**Embrey Builders, LLC**  
 1020 N. E. Loop 410, Suite 700  
 San Antonio, TX 78209  
 Ph: (210) 824-6944 Fax: (210) 824-7656

RFI # 200  
 Date: 10/22/2012  
 Job: EB-02 Keller Springs Lots  
 Phone: 877-777-5115

Subject: B2 Part 4 unit Columns and patio dimensions

SHEET NUMBER
3.1C
BLDG PLAN 'C'

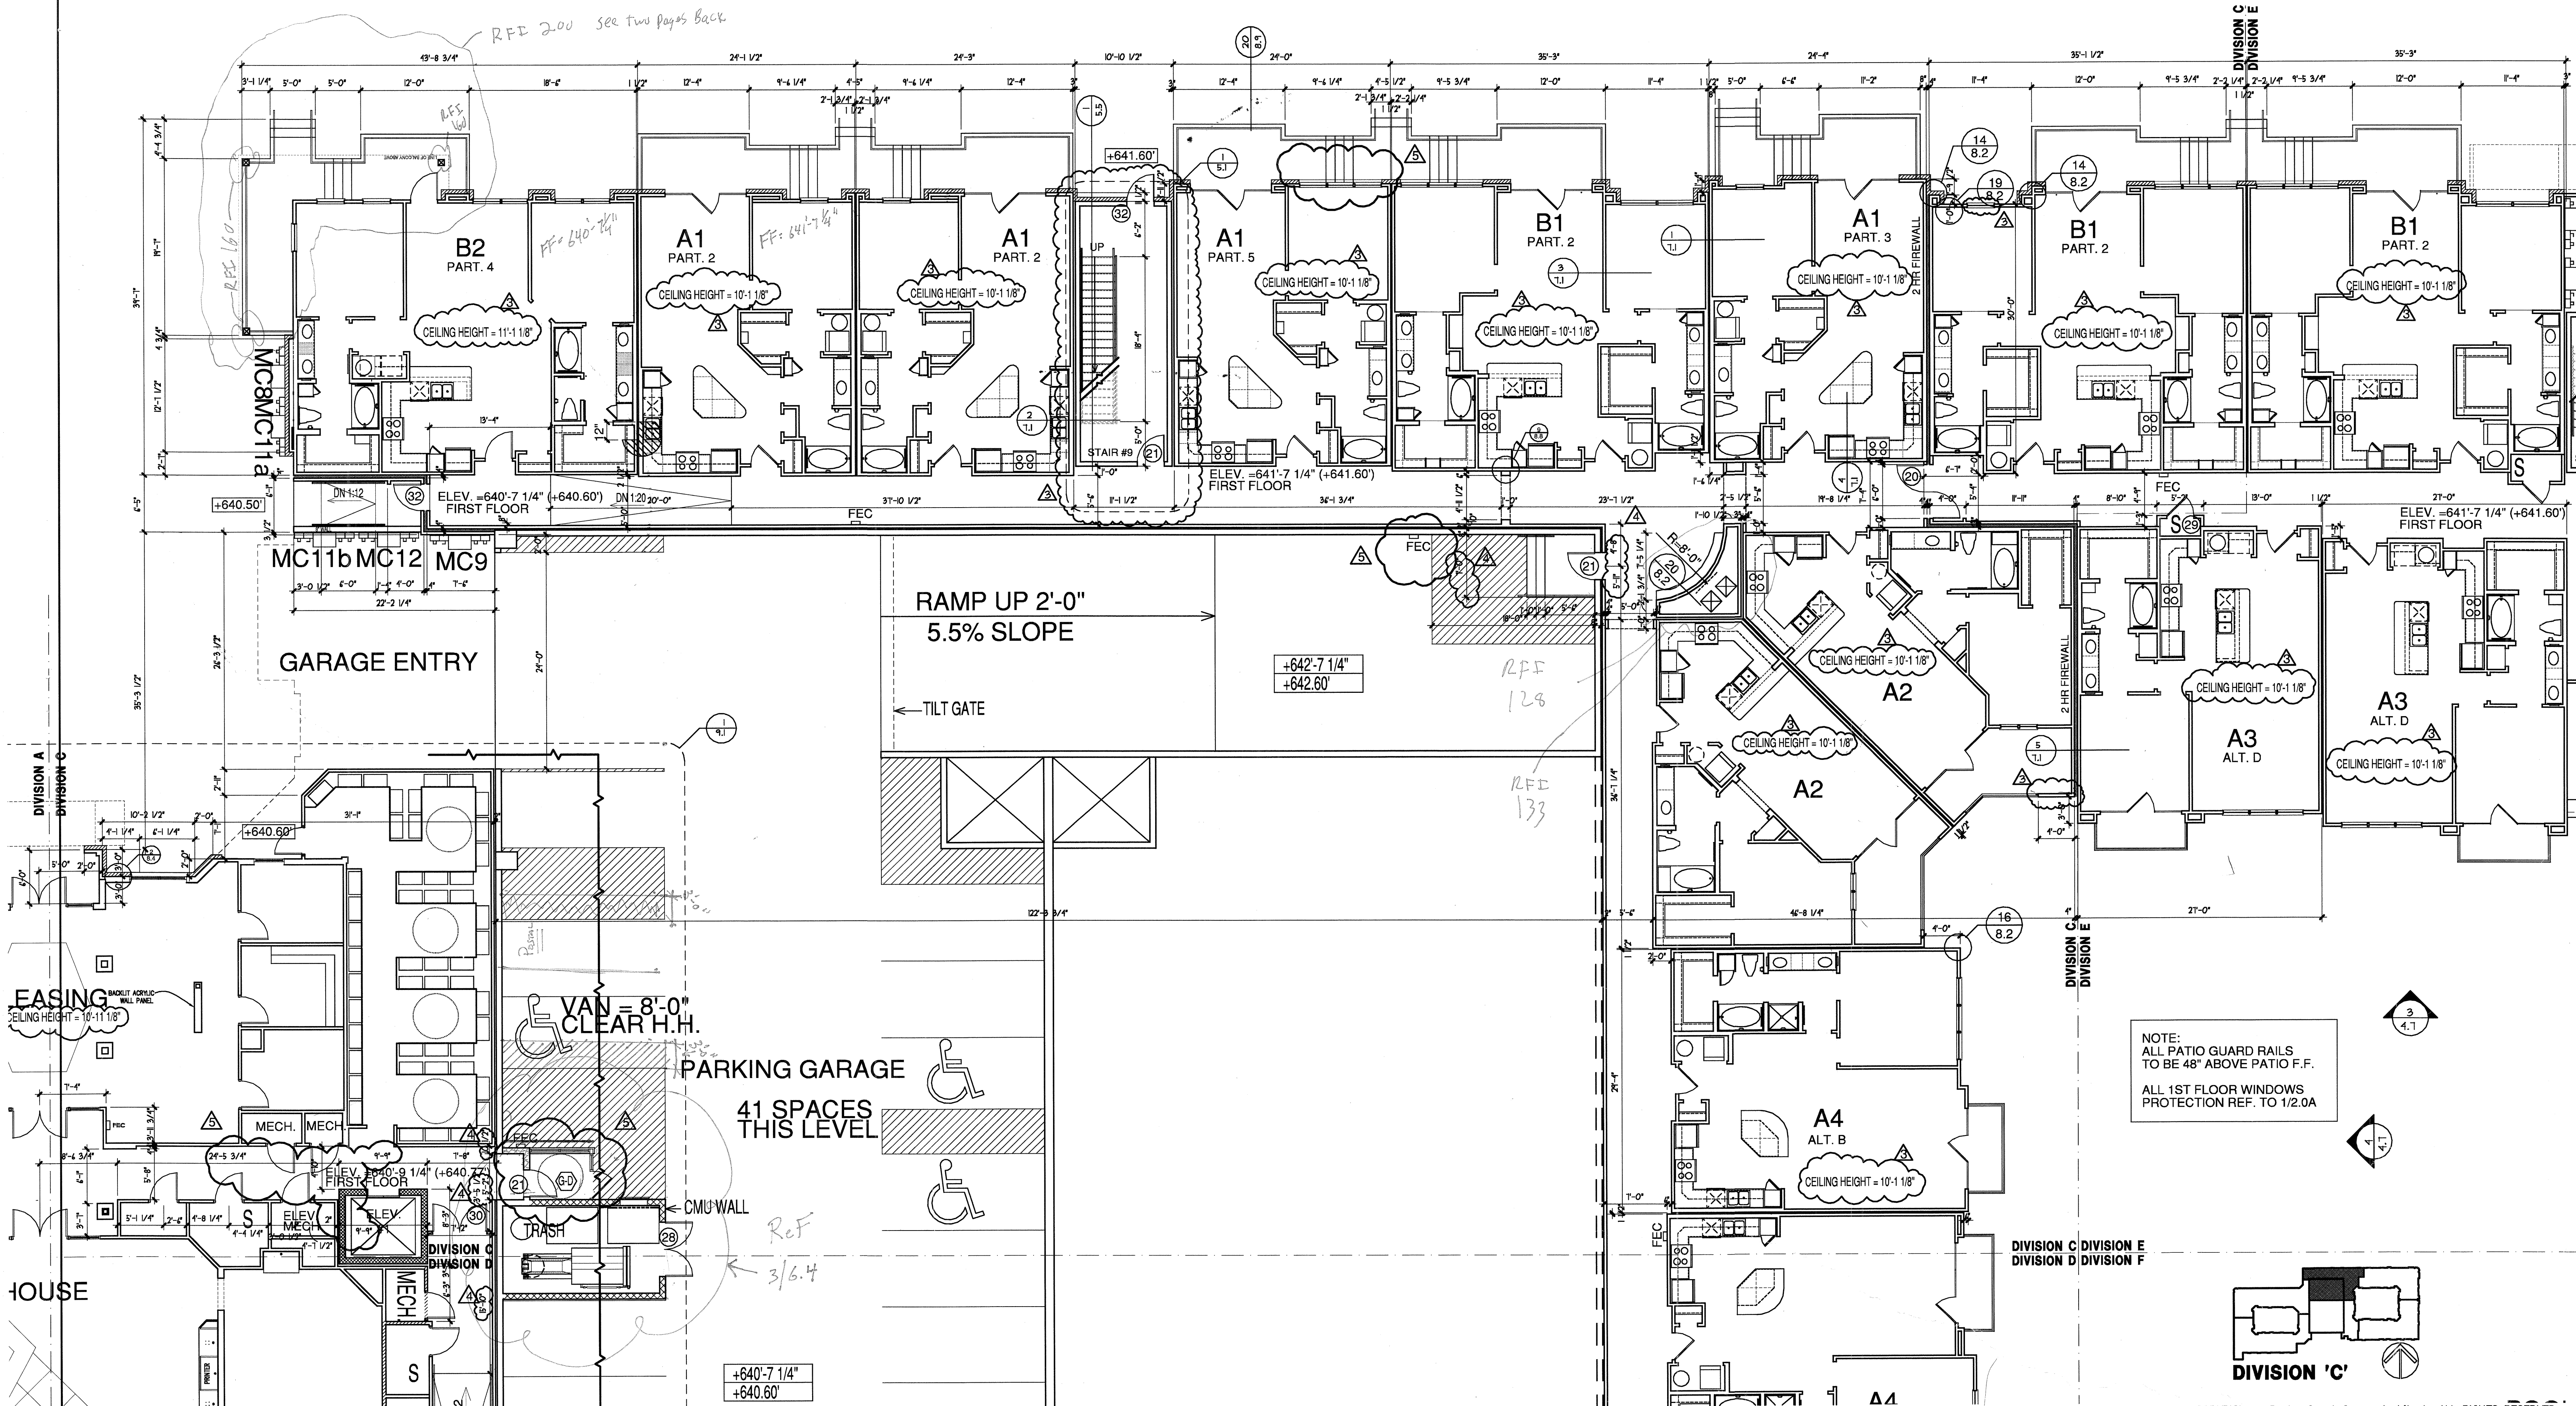
**Request:** Date Required: 10/24/2012  
 The attached RFI from Red River Framing is in reference to the B2 Part 4 unit columns and patio dimensions on 2/2.7A vs. the B2 Part 1 unit balconies above shown on 1/2.7A. The B2 Part 1 units show the supporting walls "6" past the support columns from the B2 Part 4 units. Please review and advise.

**Response:**  
 PPO takes no exception to the cantilevered truss solution proposed below.  
 Please ask BGO to confirm that the solution is acceptable Architecturally.

BGO suggests cantilevering the trusses for these B2 units in question as shown in the next pages of this PDF only if the Trusses are signed and sealed by an engineer in the state of Texas.
